Application for Planning Permission for Works or Extension to a Dwelling

Development: Rear single storey extension with balcony above. Minor fenestration changes, new patio area and 'below ground' swimming pool.
Location: 3 Bay Walk Aldwick PO21 4ET

Inconsistent Plans

PROPOSED FIRST FLOOR PLAN

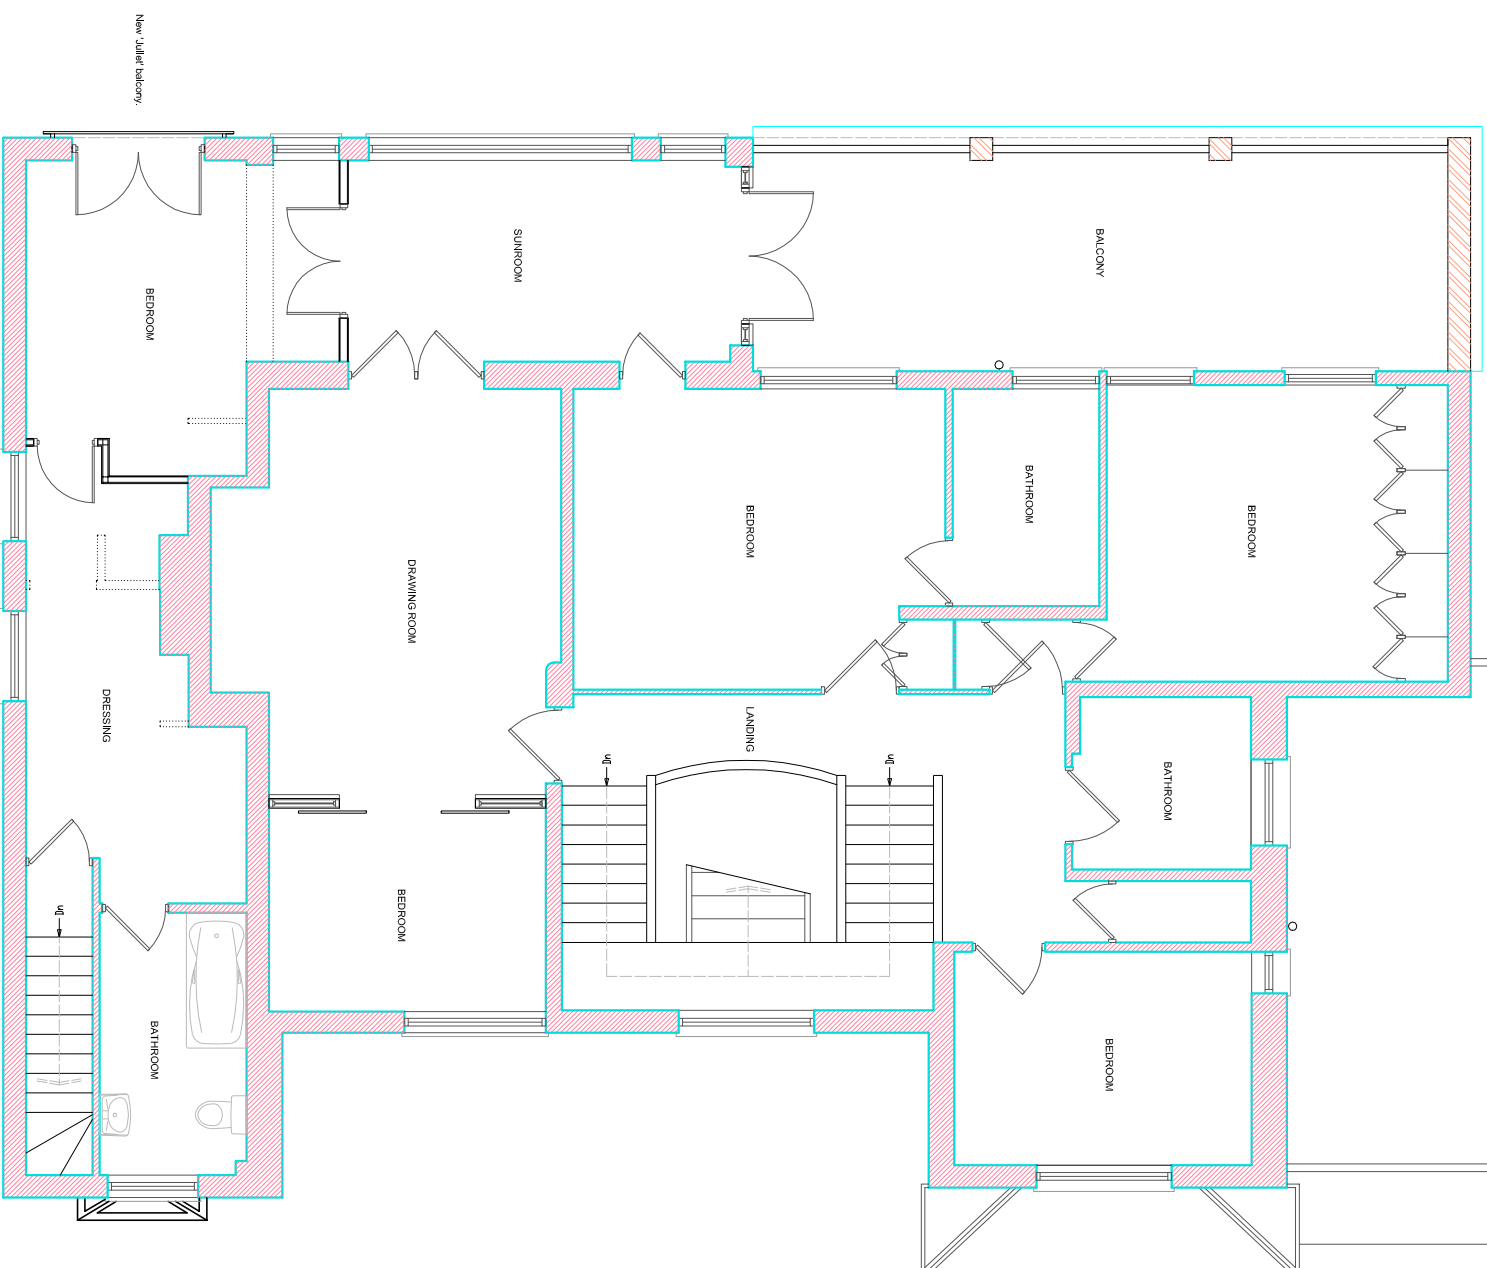
The windows are inconsistent between the first floor plans and the front and right side elevations, please review and amend.
